Broad Oak Preservation Society

Planning Act 2008 Planning Inspectorate Examination of Richborough Connection Submission to Examining Authority for Deadline Eight

SECTION B-B
BETWEEN PC8 & PC9

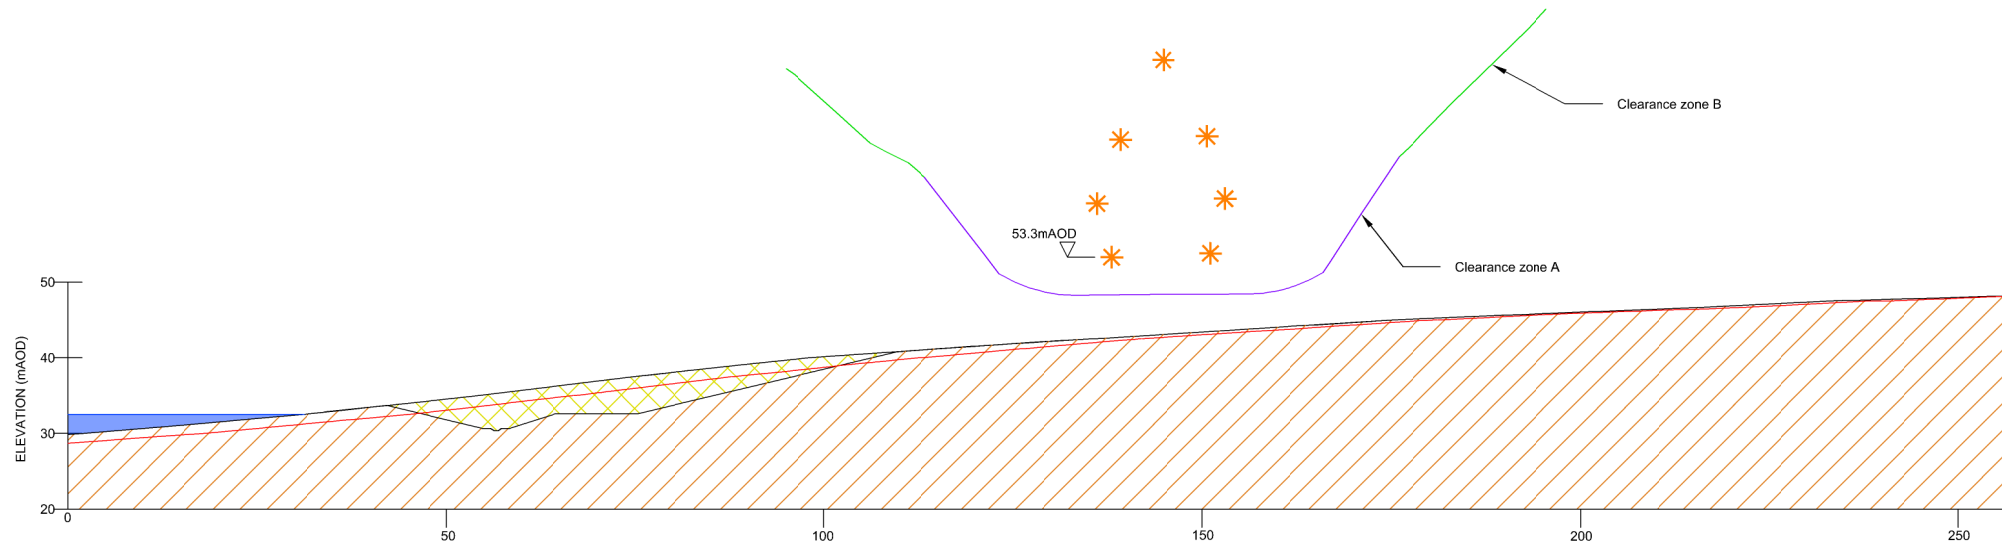
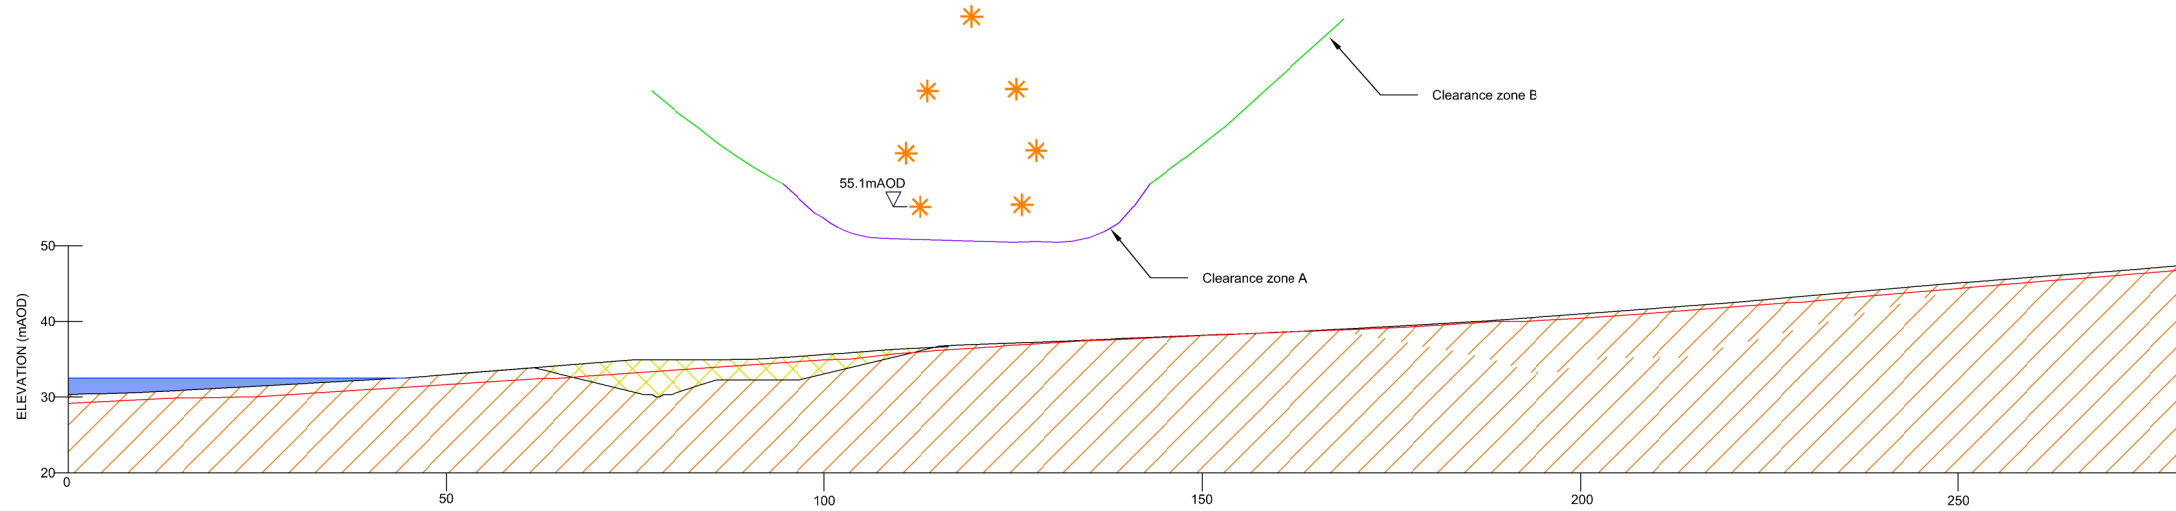
Our concern is that if this proposal was to be taken forward, it would involve raising the height of pylons PC8 and PC9, in addition to PC10. These changes would increase the perceived visual intrusion of the pylons from a number of locations within Broad Oak by approximately 10%. NG say the change would be within the limits of variation; notwithstanding that we consider the changes would be of such significance as to warrant further public consultation. All the illustrative material prepared by NG for the earlier consultations was based on the planned height of the pylons, not the maximum height possible within the limits of variation.

To illustrate the impact of increasing pylon heights, we will consider pylon PC8. This pylon is located 160m from the corner of the garden of Nook Farm. The pylon base is on the 44m contour while Nook Farm is on the 51m contour, so part of the height of the pylon is lost down the slope against the background vegetation and the far side of the valley. If we assume a line of sight from an observer at eye level 1.5m above ground level, the top of a 50m pylon will be 41.5m above the horizontal line of sight, and the line of sight to the top will

be at an elevation of 14.5°. If the pylon height is raised by 4m, the corresponding figures become 45.5m and 15.9° respectively, increases of approximately 10%.

The increase in height may be sufficient to make the pylon top visible above the sky-line when it previously would not have been so prominent. These effects should be thoroughly evaluated for PC8, PC9 and PC10 before any decision is made to adopt this proposal. The visual receptors potentially affected are Nook Farm and other properties on Mayton Lane, The Golden Lion public house and properties at the western end of Sweechgate, and Foxhill House and other properties in Herne Bay Road.

**SECTION D-D**  
THROUGH PC9

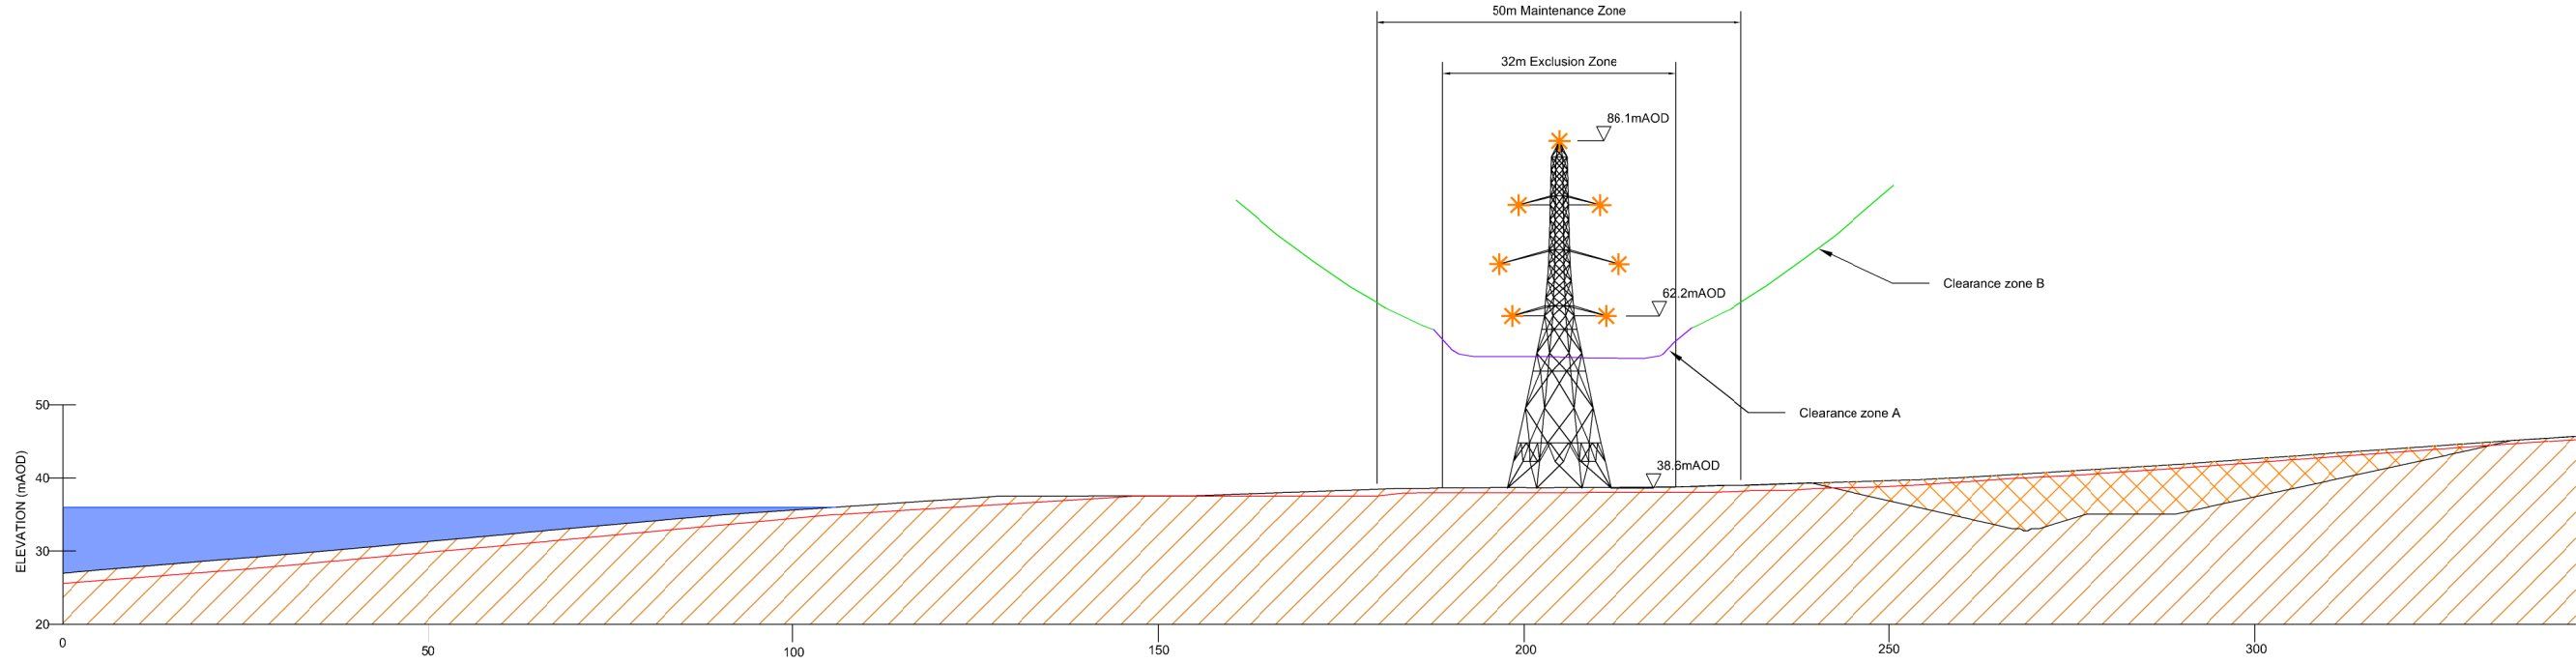
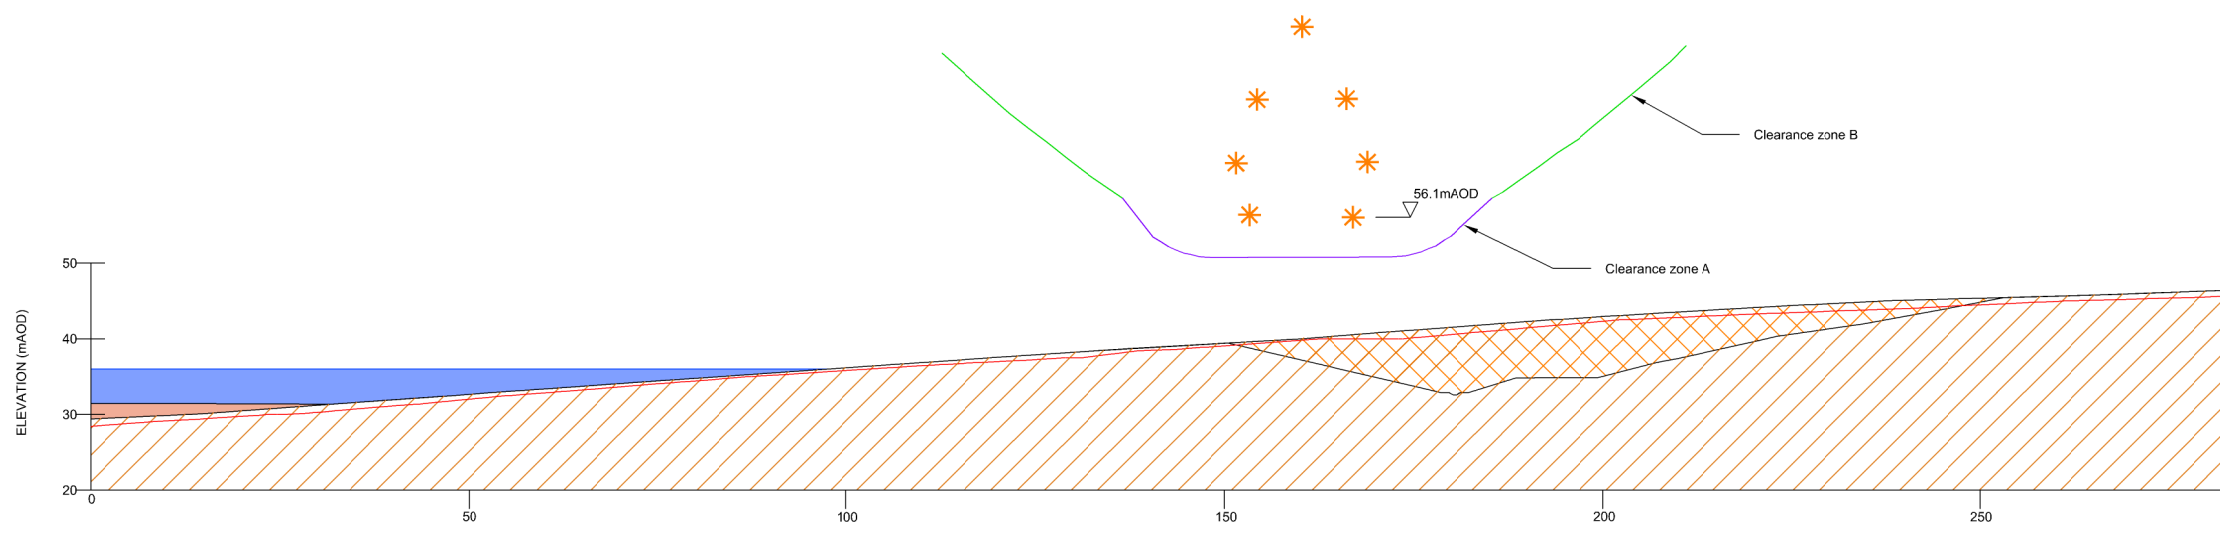
Initially we wish to address the question of increased pylon heights. We were very concerned to learn that at one of the Issue Specific Hearings looking at the clash between the proposals by NG and South East Water (SEW) both organisations had been asked to examine the implications of moving pylon PC10 to a new location where it would not conflict with SEW's provisional plans for the fish pass associated with the proposed new reservoir. Both NG and SEW disclaimed responsibility for originating this proposal, which we must therefore assume comes from an enquiry by the Examining Authority as to whether it might be possible to resolve the conflict between the two authorities' schemes by a simple adjustment to pylon positions. We trust this question does not imply that the Examining Authority has already pre-judged the outcome of the examination, but was merely seeking information as to whether a resolution of this particular conflict might be possible.

We understand that neither NG nor SEW have looked on this proposal favourably. The evidence given by SEW at the most recent ISH appears to suggest that the relocation of pylon PC10 would make the situation worse with the cables coming closer to the stream diversion line at the point of lowest sag.
